KIRKLEES METROPOLITAN COUNCIL INVESTMENT & REGENERATION SERVICE

DELEGATED DECISION TO DETERMINE PLANNING APPLICATIONS

Reference No:	2024/62/92174/W
Site Address:	88, Bradley Road, Bradley, Huddersfield, HD2 1QY
Description:	Raising of roof height to create first floor accommodation, erection of extensions and alterations
Recommending Officer:	Lucy Taylor

Officer Report.

WEST ELEVATION

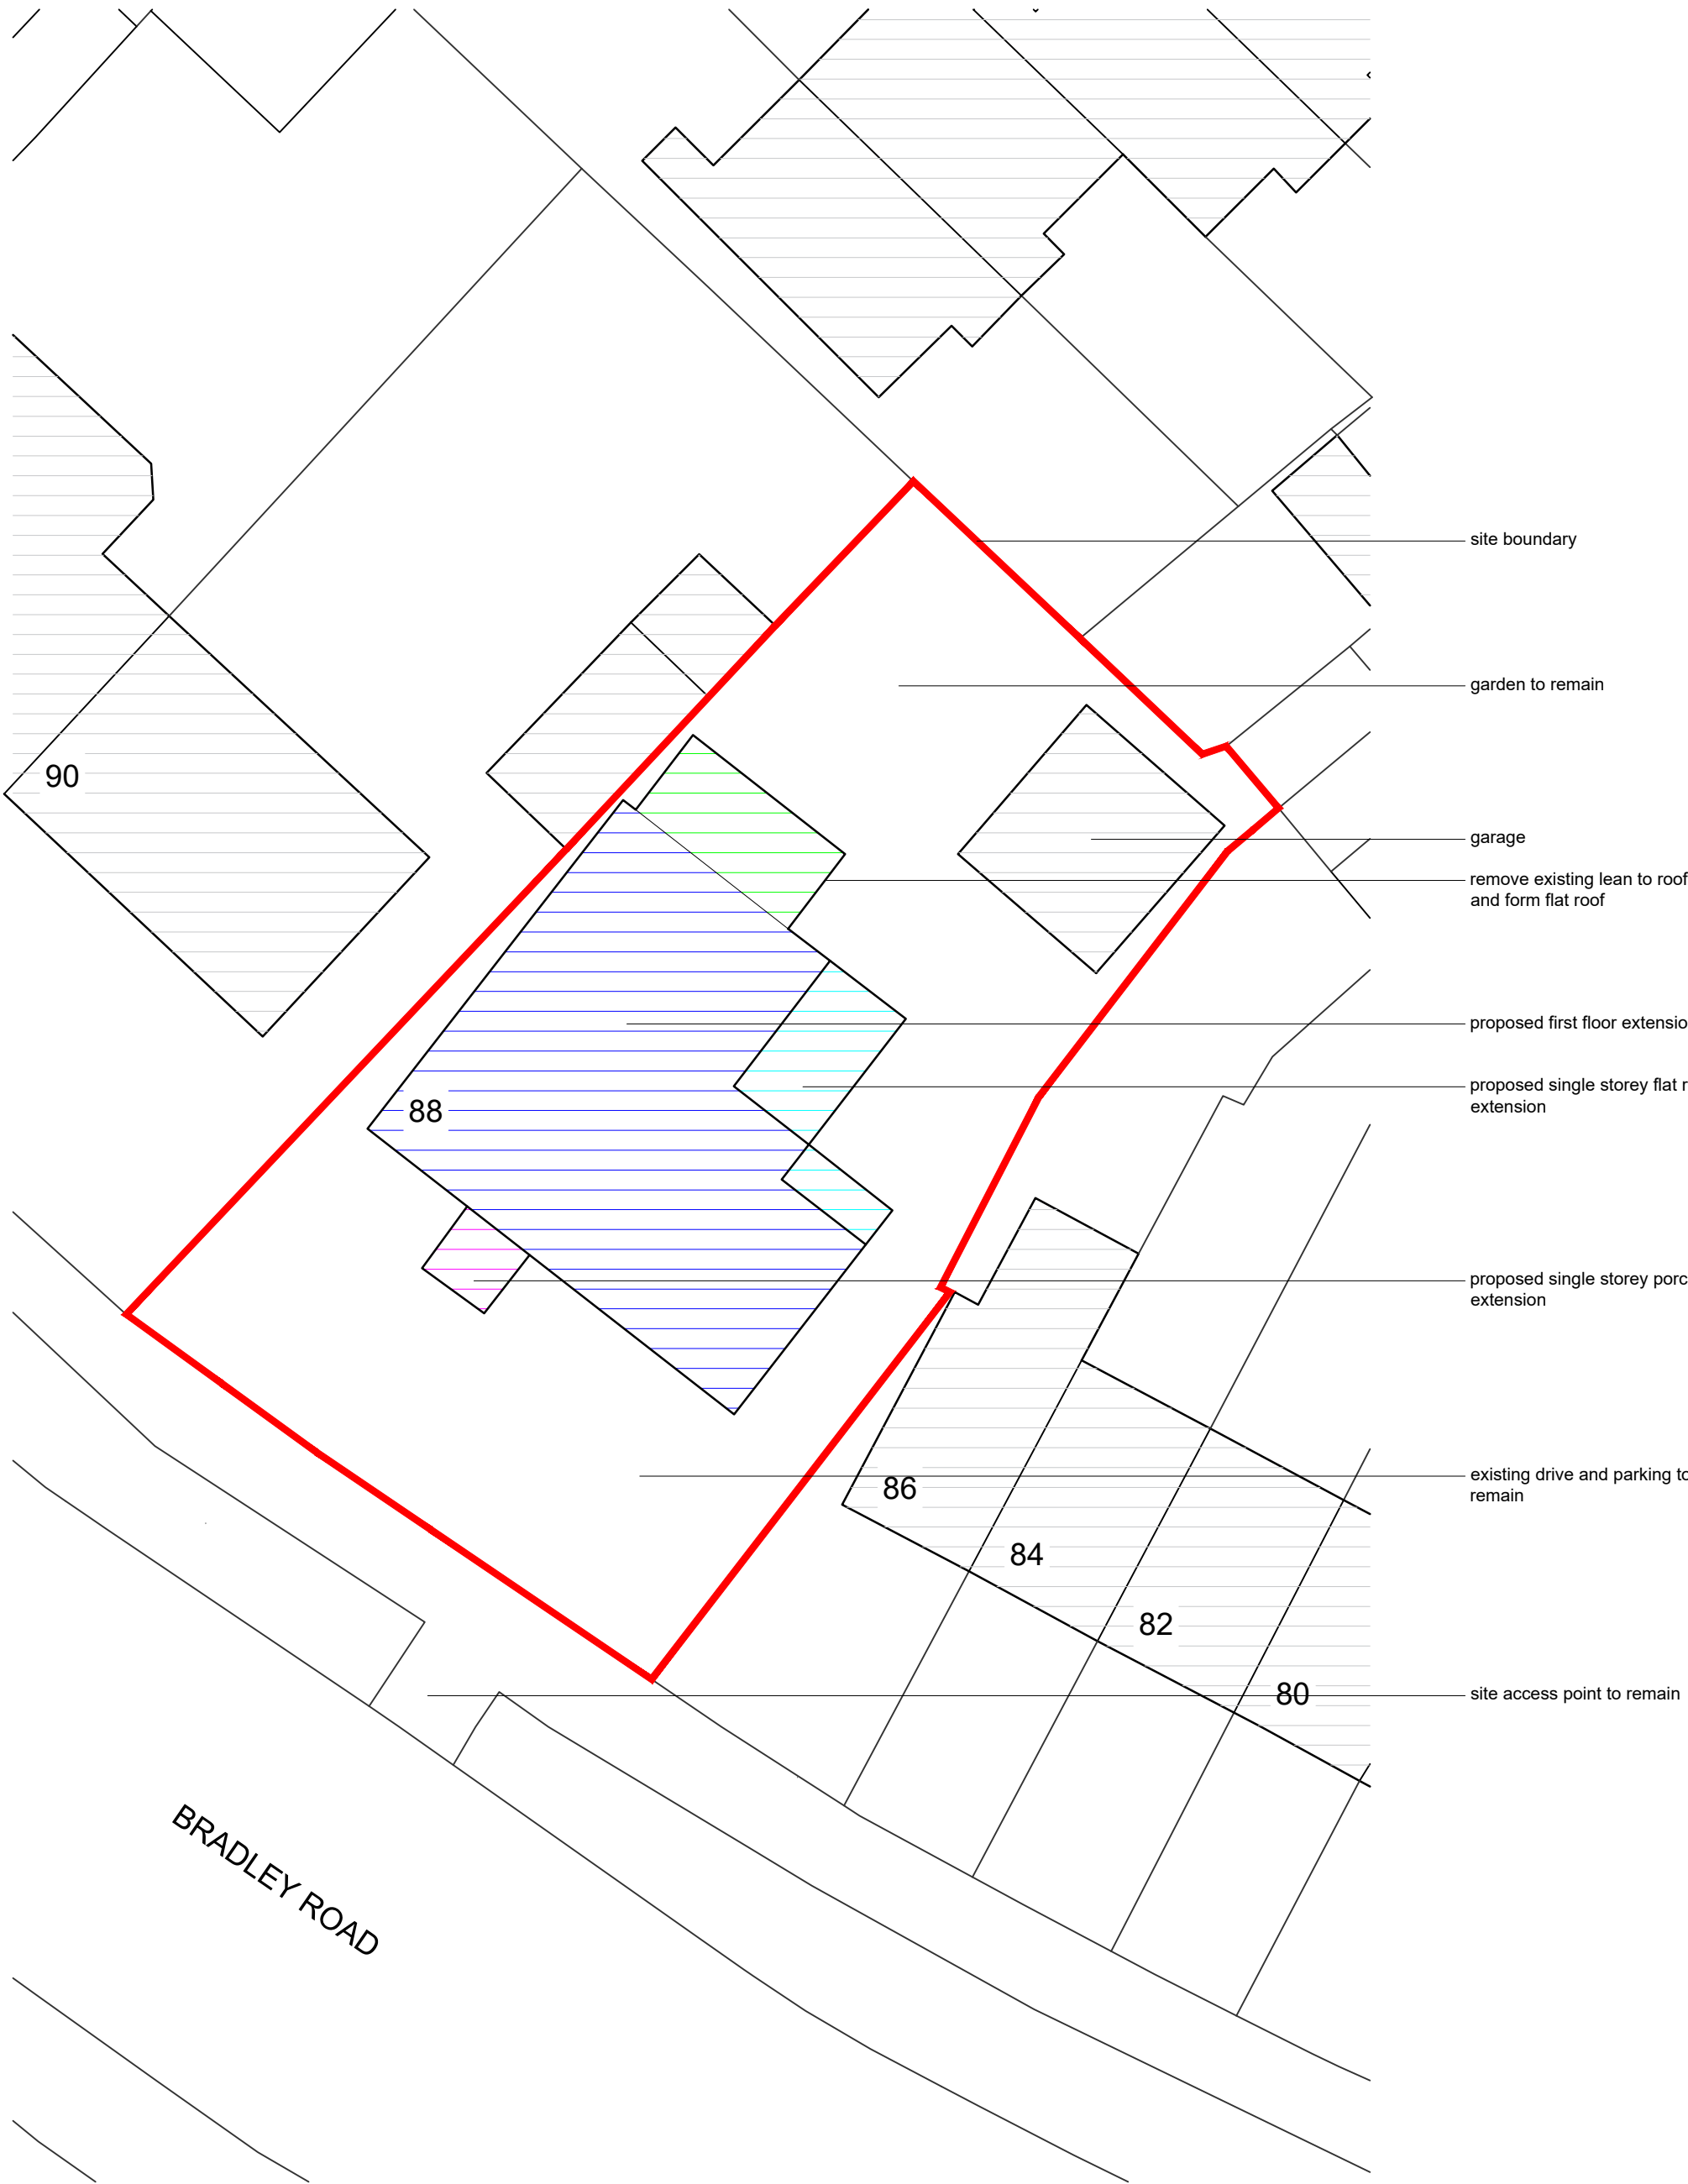
The amended plans submitted for this application show that the eaves height of the host dwelling would be raised to 4.2 metres to the rear, with the eaves height of the host dwelling proposed to be raised to approximately 3.8 metres to the rear under previously refused application 2022/92993. Therefore, the proposed extent of built form relating to the eaves height of the host dwelling is greater than that proposed under the previously refused application by approximately 0.4 metres.

With regard to the two-storey gable extension, the eaves height of this addition under this application is to be a mix of 4 metres and 3.6 metres.

Therefore, it is considered that, on balance, this application would present unacceptable impacts to residential amenity, reintroducing reason 2 of previous refusal of application 2022/92993 with regard to impacts to No. 90 Bradley Road, especially with regard to the building up of the eave's height to the rear of the host dwelling and the eaves height proposed to the two-storey rear extension. Overall, therefore, the proposal is considered to have an unacceptable impact on residential amenity, leading to an unacceptable impact upon No. 90 Bradley Road.

1. The proposed raised eaves and ridge height of the host dwelling, and the proposed two-storey gable rear extension, cumulatively, by virtue of their scale, design and siting would lead to a detrimental overshadowing and overbearing impact to the occupiers of No. 90 Bradley Road. Therefore, the proposal would fail to retain a high standard of amenity for existing occupiers of this neighbouring dwelling, contrary to Policy LP24 of the Kirklees Local Plan, Key Design Principles 4, 5 and 6 of the Kirklees House Extensions and Alterations Supplementary Planning Document and Chapter 12 of the National Planning Policy Framework.

In response to the case officers' comments, amended plans were submitted, to show the eaves height to the rear reduced by 0.6 metres.

FIRST FLOOR PLAN

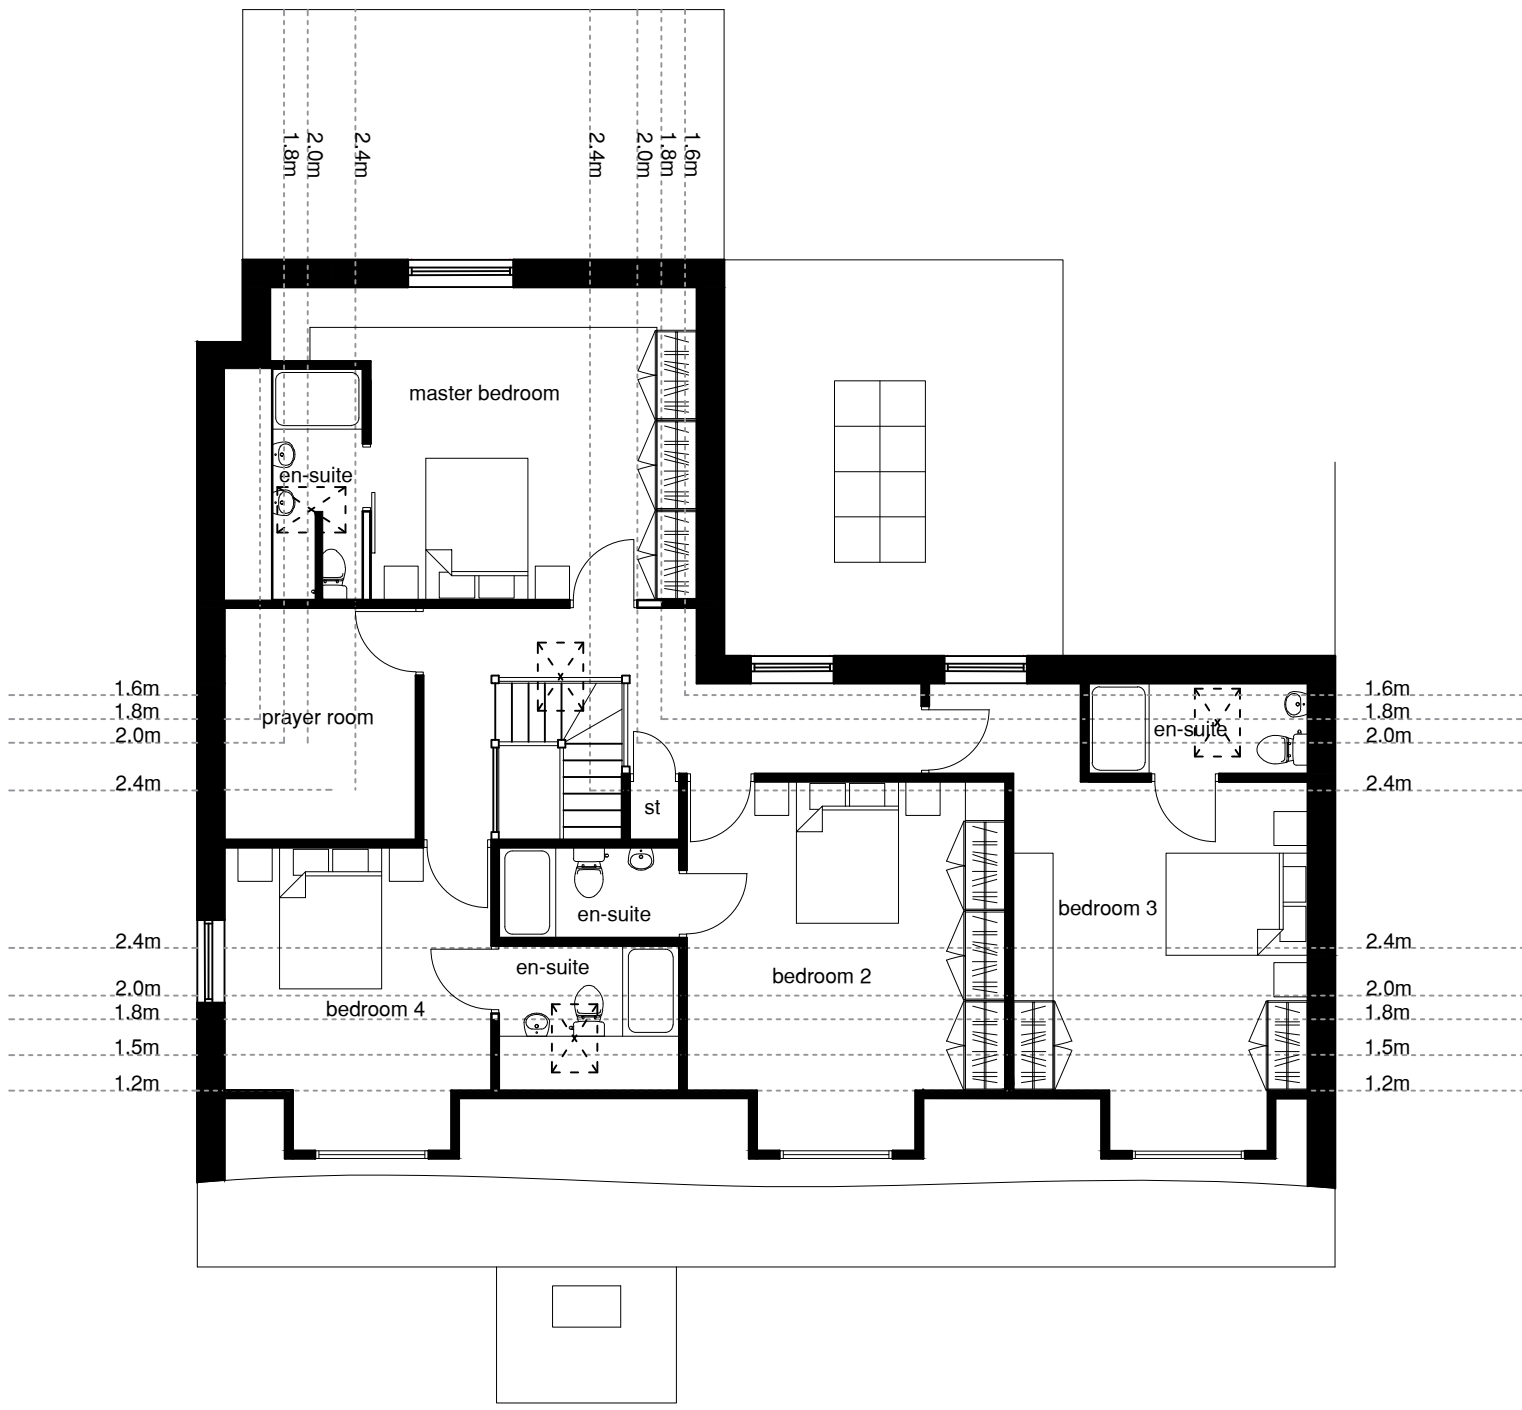
Whilst a bedroom window is proposed to the first floor of the western elevation No. 88, officers note that this would not change the existing relationship between No. 88 and No. 90 with regard to residential privacy, with a first-floor bedroom window installed to this elevation of the existing property. In addition, the floor plans show that the ground floor window to this elevation is to serve a bathroom and therefore, would likely be obscure glazed. A condition could
